OXFORDSHIRE COUNTY COUNCIL'S RESPONSE TO CONSULTATION ON THE FOLLOWING DEVELOPMENT PROPOSAL

Application no: 23/00517/F

Proposal: Redevelopment of the site to include the demolition of existing buildings and development of new accommodation across 5 buildings for employment uses (Class E(g)(ii) and (iii)) plus ancillary amenity building, outdoor amenity space, car parking, cycle parking, landscaping and associated works

Location: New Science Park Land West Of The Junction With The Boulevard, Oxford Airport, Langford Lane, Kidlington

Drawing Title
Foul Drainage Layout

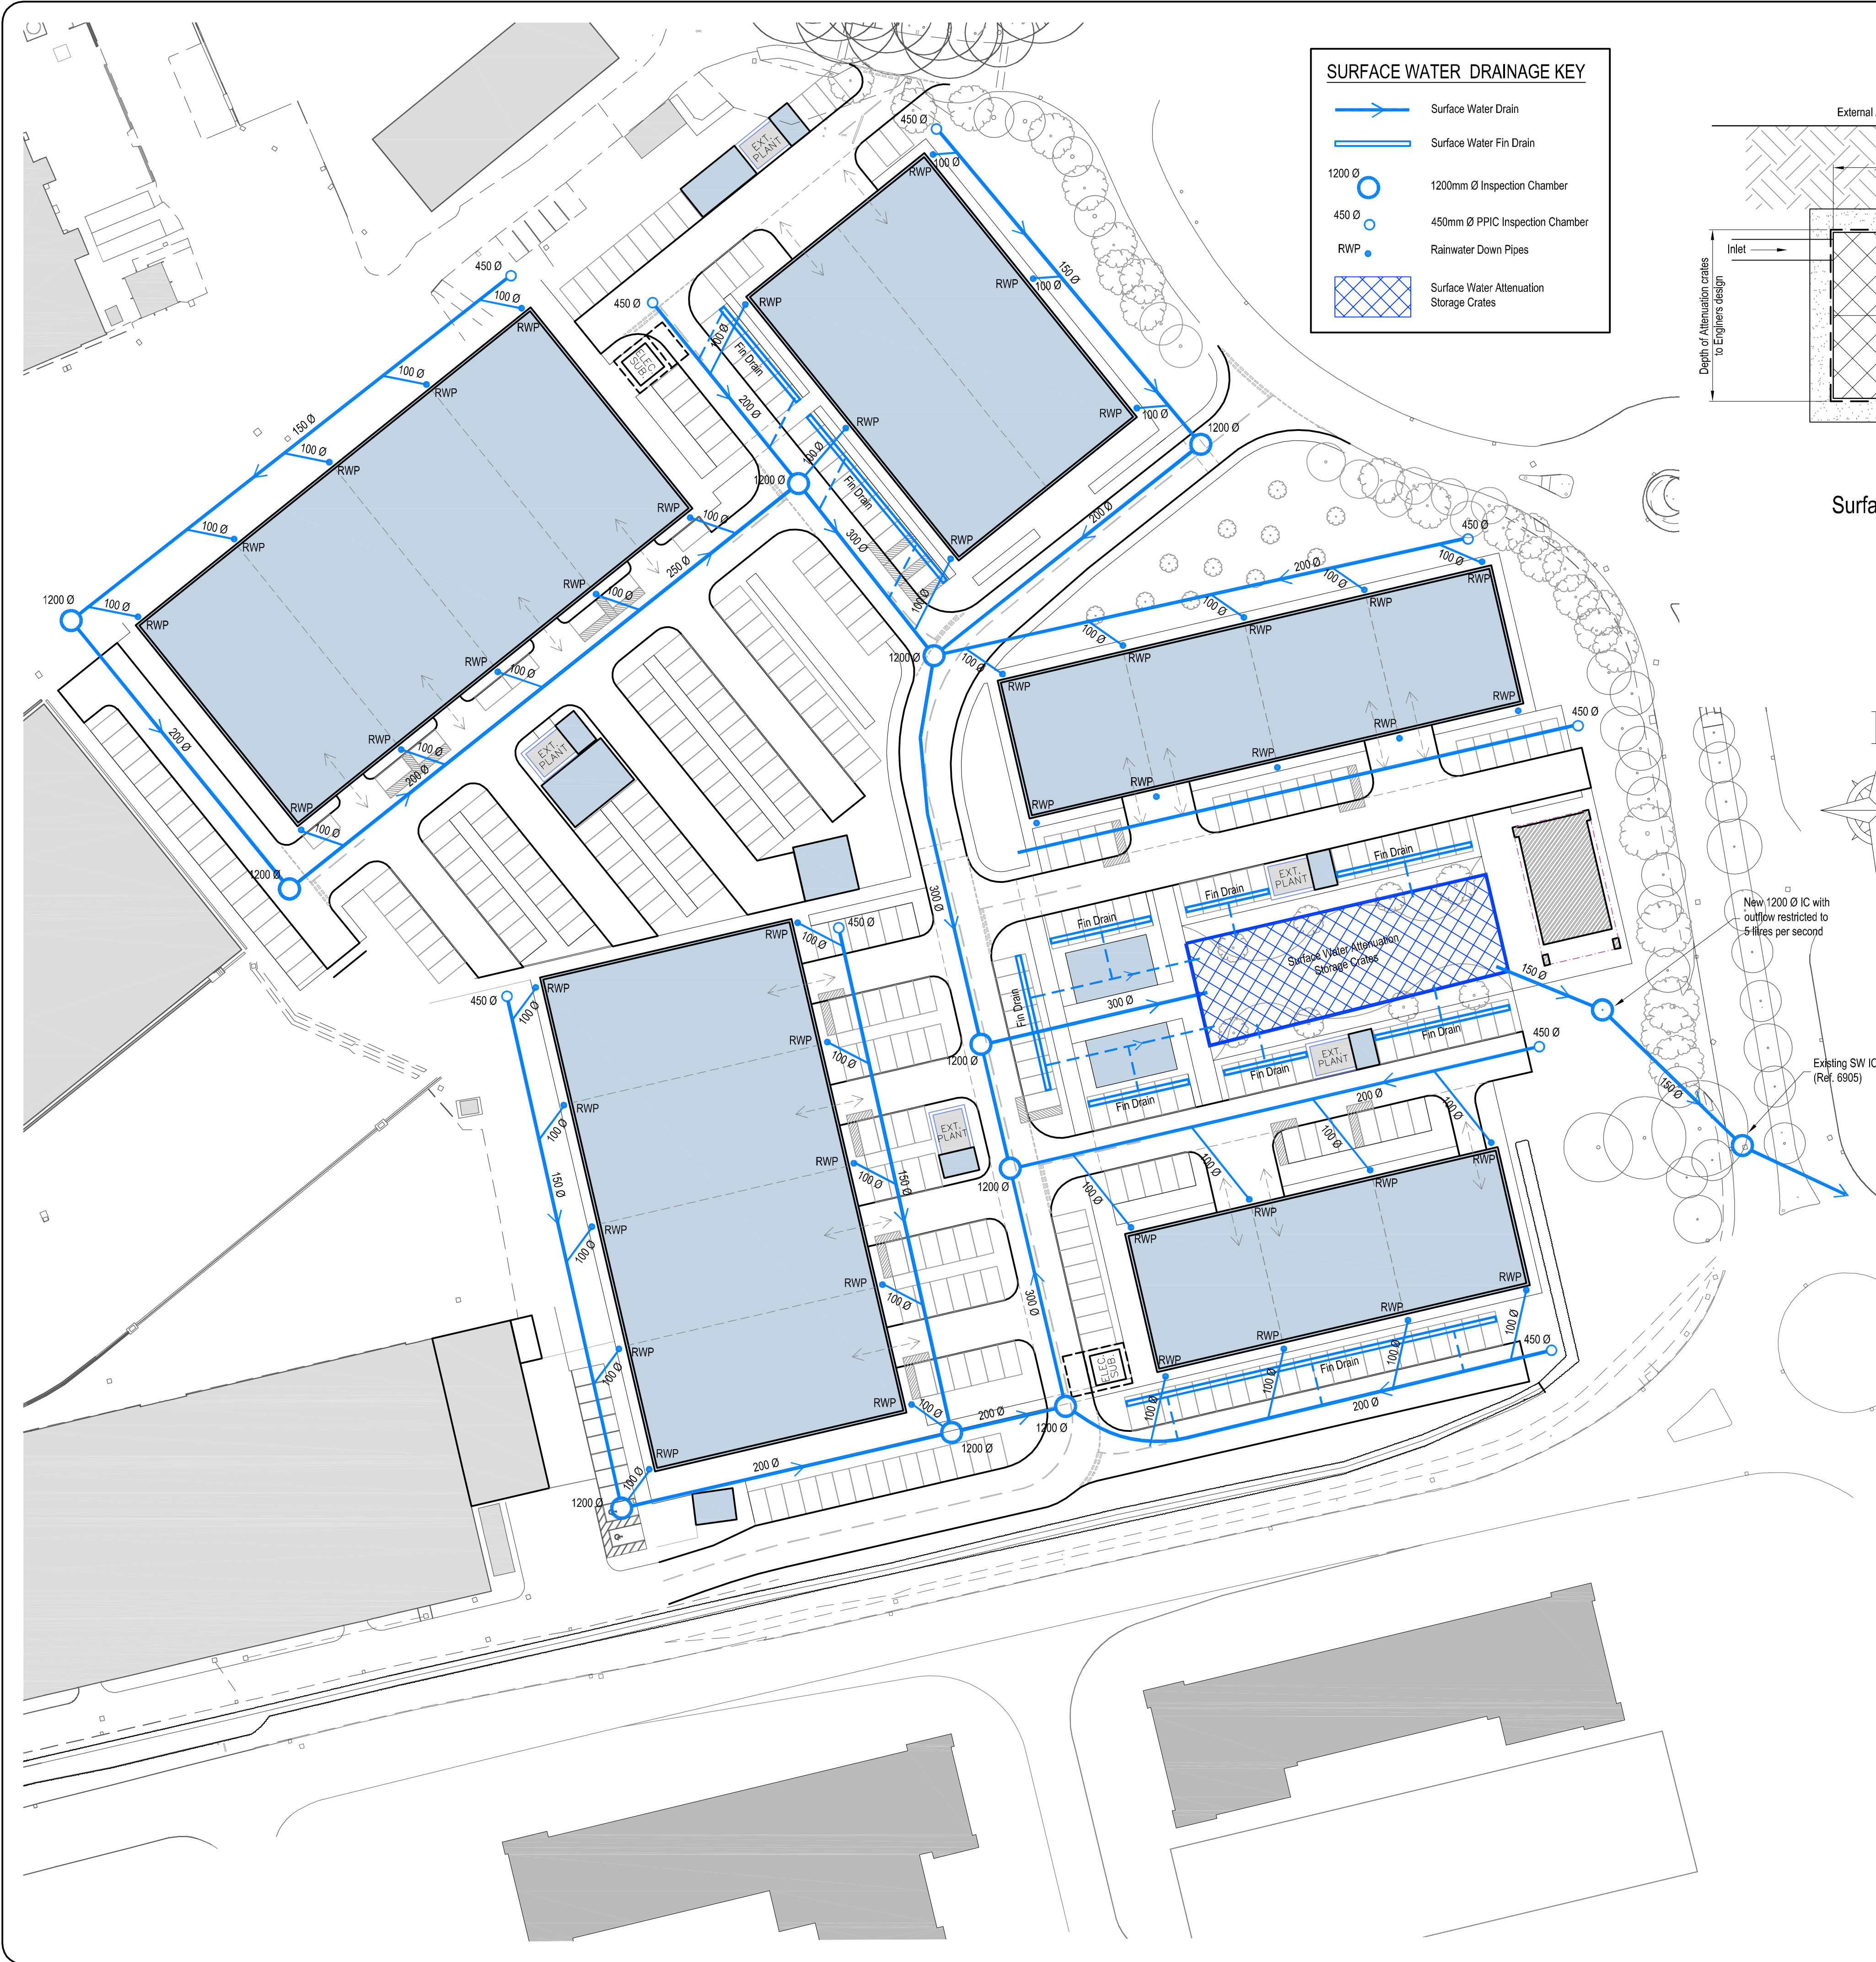
Drainage plan to include the site boundary to illustrate the extent of ownership. It's difficult to review the drainage plan without knowing the extent of the applicants land ownership.
